Huntlee New Town Residential Subdivision Stage 1 (MP 10_0137 MOD 11)

The Biodiversity and Conservation Division (BCD) of the Department of Planning Industry and Environment (the Department) has reviewed the submission for Modification 11 'Section 4.55(1a) Modification Application MP_10_0137 (Mod 11) Huntlee New Town, Branxton' prepared by Ethos Urban, and dated 7 November 2019. BCD understands Mod 11 involves the creation of one additional residential lot within residential Stage 16 (R16) as a result of the subdivision of superlot 222, and one additional Town Centre commercial lot within TC1, delays in the timing for the road upgrade, minor road and lot boundary alignment amendments, and a request to change conditions of consent.

BCD's detailed comments

FIGURE 4D

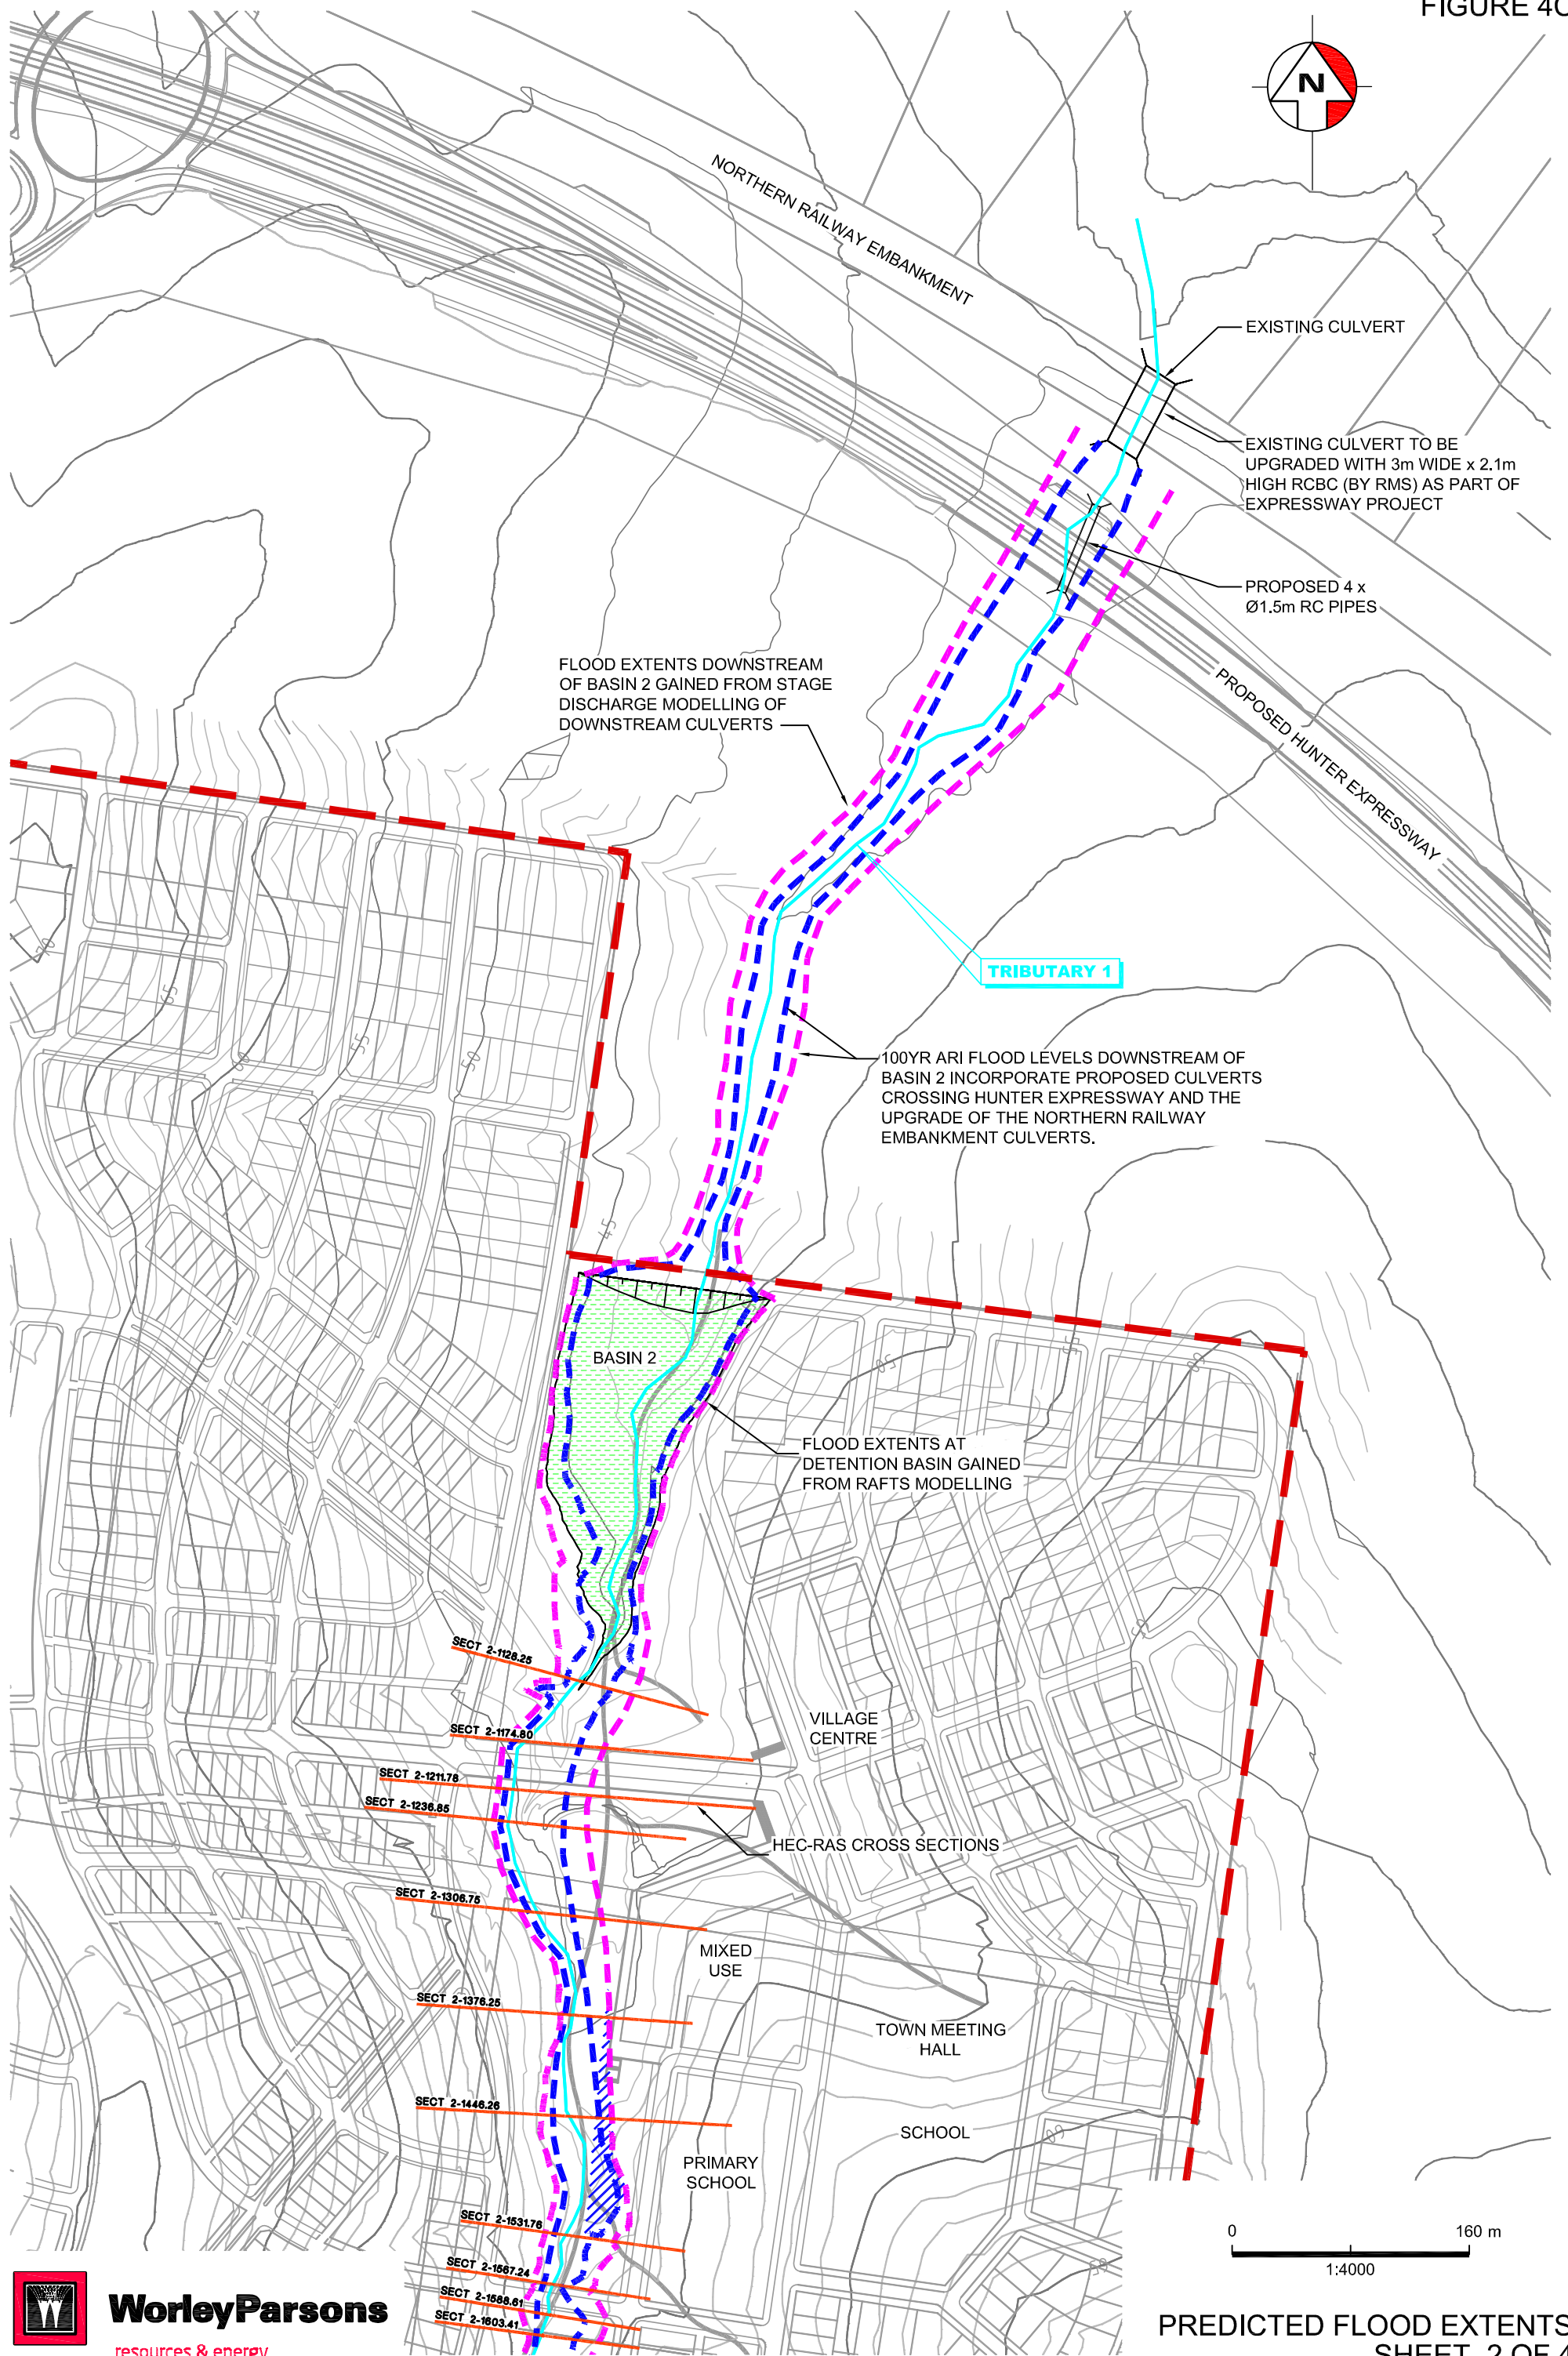
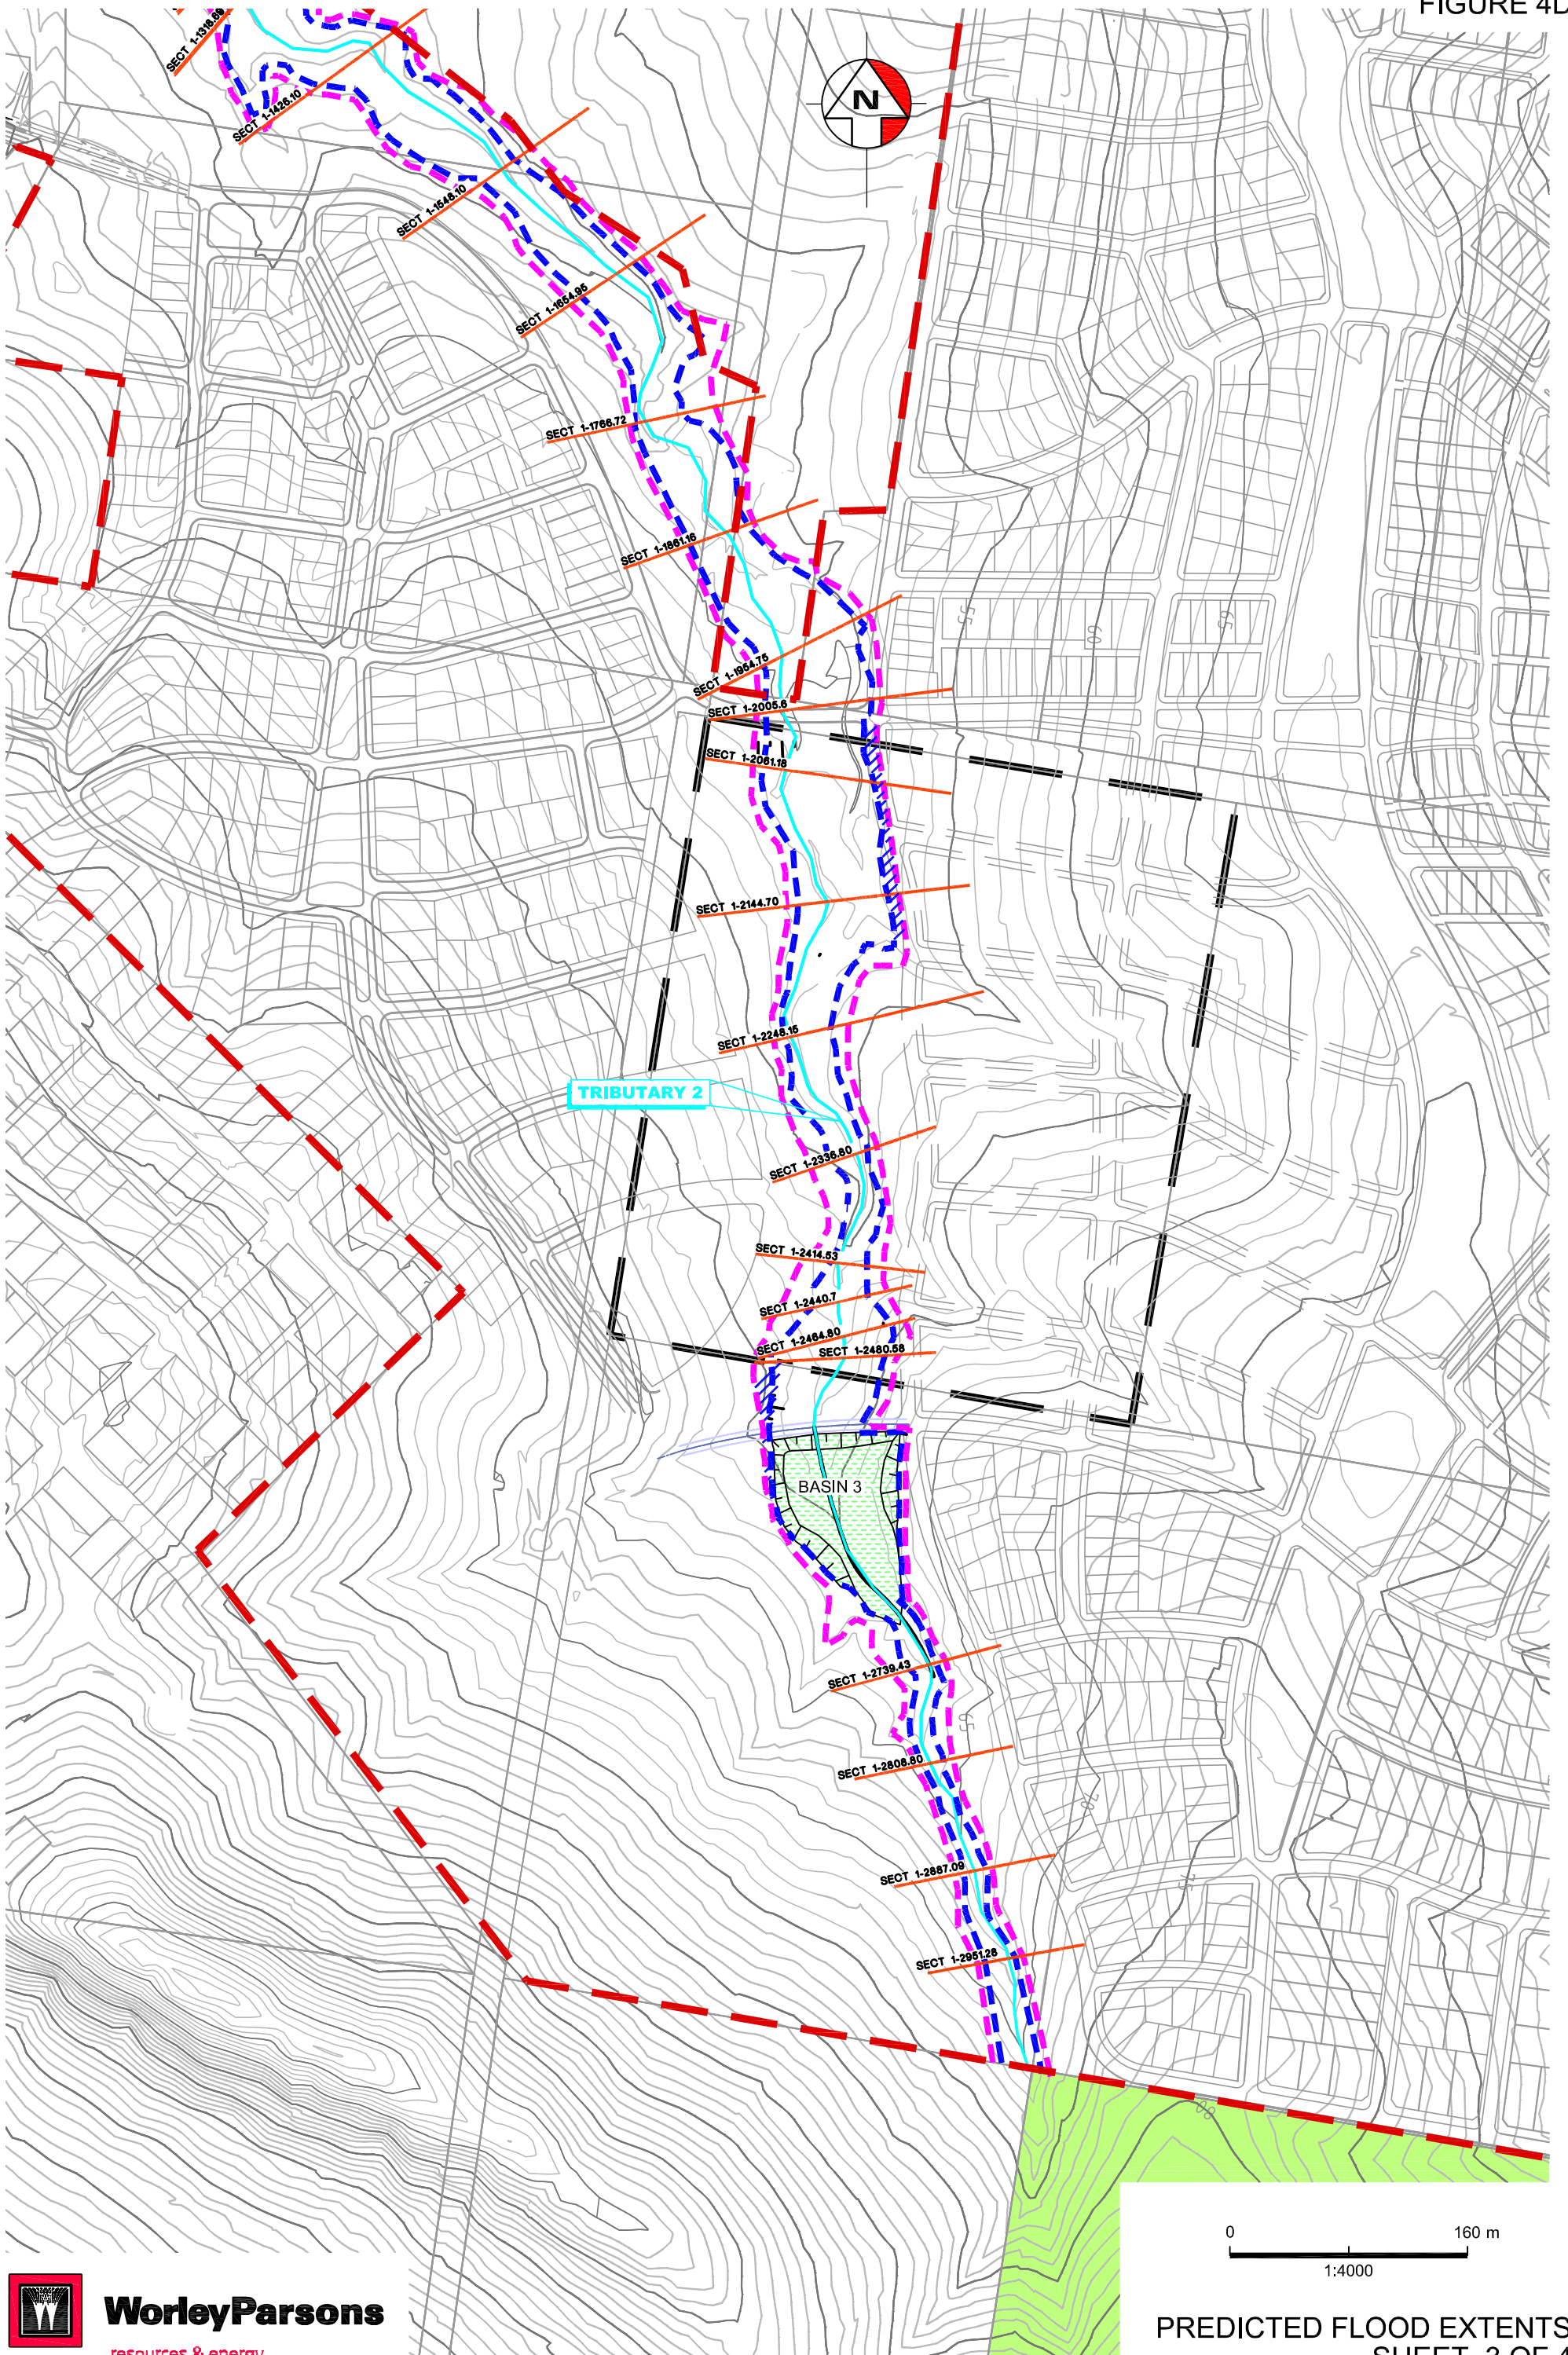
Attachment E, Huntlee Stage 1 Constraints on Amended lots shows the flood extent on the proposed lots. This plan is of too small a scale to determine if encroachment into the flood extent has occurred. Mod 11 presents the Worley Parsons flood map in support of the changes. The flood map is for the original subdivision and the flood extent shown on Attachment E differs from that on the Worley Parsons mapping.

Flood mapping needs to be updated to reflect the revised on-site detention structures, lot layout and flood extent. Mapping provided is to overlay flood extent on the proposed lot layout at adequate scale to enable impact to be assessed.
